**Re: Objection to Planning Application 2025/91303**

I am writing to formally object to the planning application 2025/91303 submitted by Mr S. Patel for the proposed development at Clough Farm Meadow, 34 Tolson Street, Ossett, WF5 9QH. As a resident of the neighbouring property, I have significant concerns regarding the impact this development will have on the local community and my property.

Drawing Title **SITE PLANS**

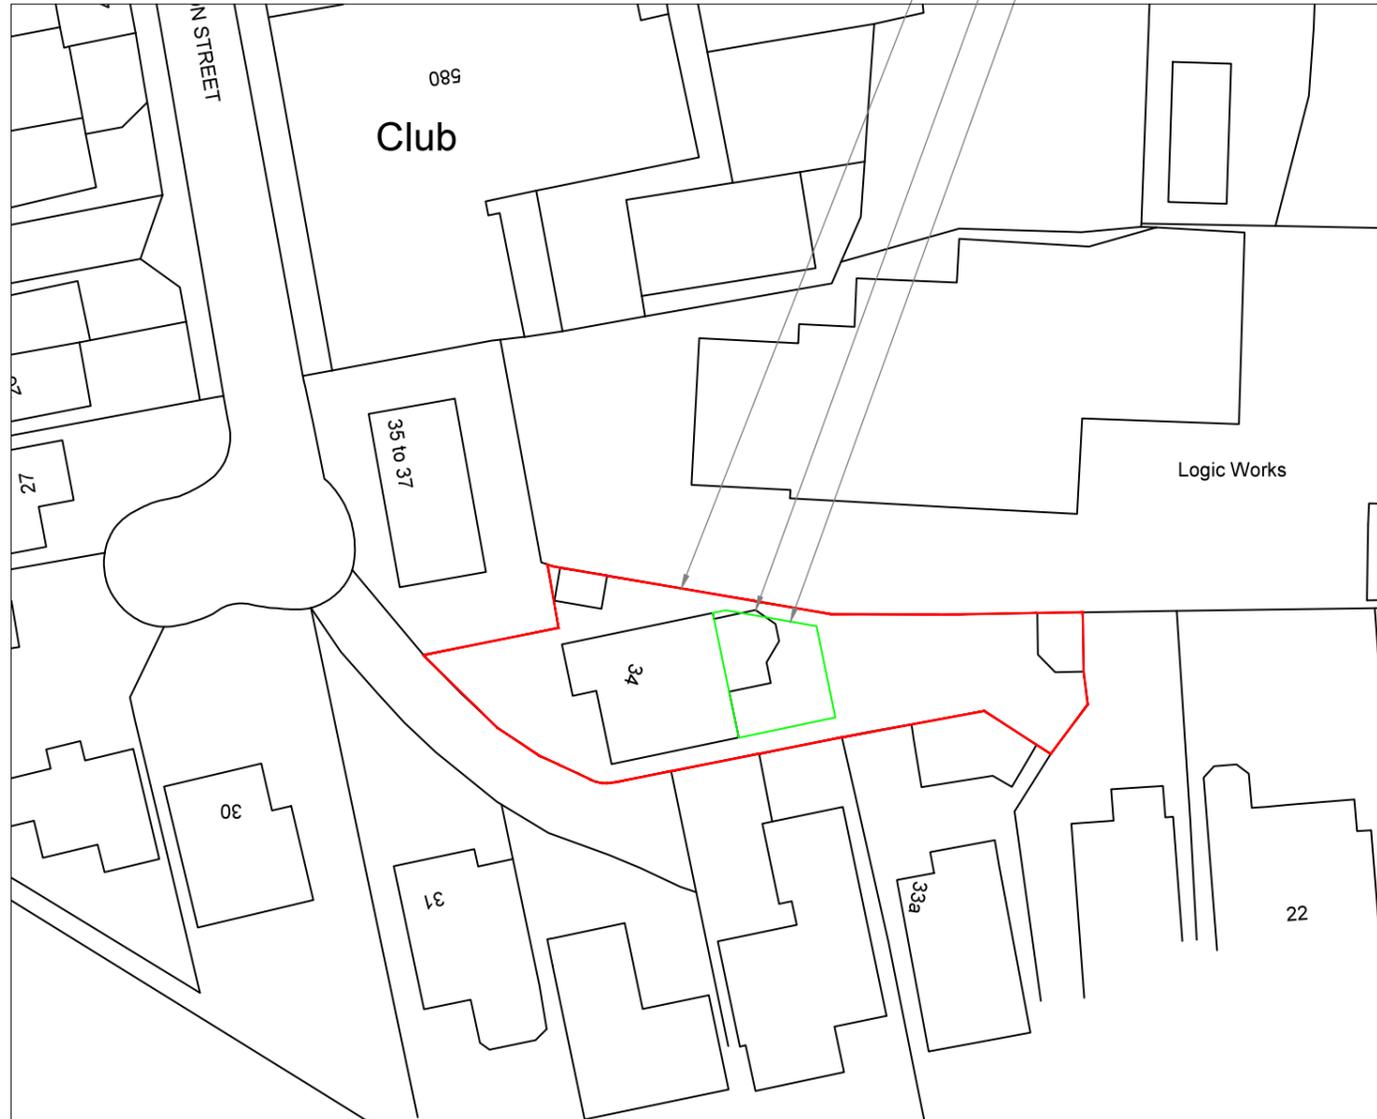
The proposed development will result in a significant loss of privacy for my property. The new building will overlook my home and garden, leading to an unacceptable level of intrusion into my private life. The proposed development is in an elevated position approximately 1200mm higher than my ground level. The proposed extension will contravene the current 45° rules as I have two windows (one living room and one bedroom on ground floor) this would mean potentially we would be overlooked as the 45° rule is not being adhered too, along with limited detailed drawings/plans of the extension should windows be in the southern and eastern elevations. The current proportions of the extension would contravene policy from distance between windows as set out in planning policy BE12 (see attached drawing) the current distances are not acceptable from the front of my dwelling to the back of the proposed extension.

The height and proximity of the proposed development will block natural light to my property. This will adversely affect the quality of life for my family and me, as we will lose access to sunlight in key living areas such as our living room and ground floor bedroom. Due to my ground level being 1200mm lower than the proposed extension it would make the overall height 4200mm from my ground level. Leading to an overlooking and overbearing extension along with significant loss of light and privacy.

The scale and design of the proposed development are not in keeping with the character of the surrounding area. The new building is disproportionately large compared to the existing structures, which will negatively impact the aesthetic and harmony of the neighbourhood. We feel it would give a tunnelling effect between dwellings due to the size of the Southern elevation becoming approximately 17,000mm with the additional extension, causing significant overshadowing and feel that it would be a goss overdevelopment of the site.

Due to the boundary also being a retaining wall, and within 1000mm approximately, I have major concerns around the long term integrity of the boundary retaining wall, there will be increased pressure from the foundations along with the size of the extension unless the foundations are deeper than the party wall.
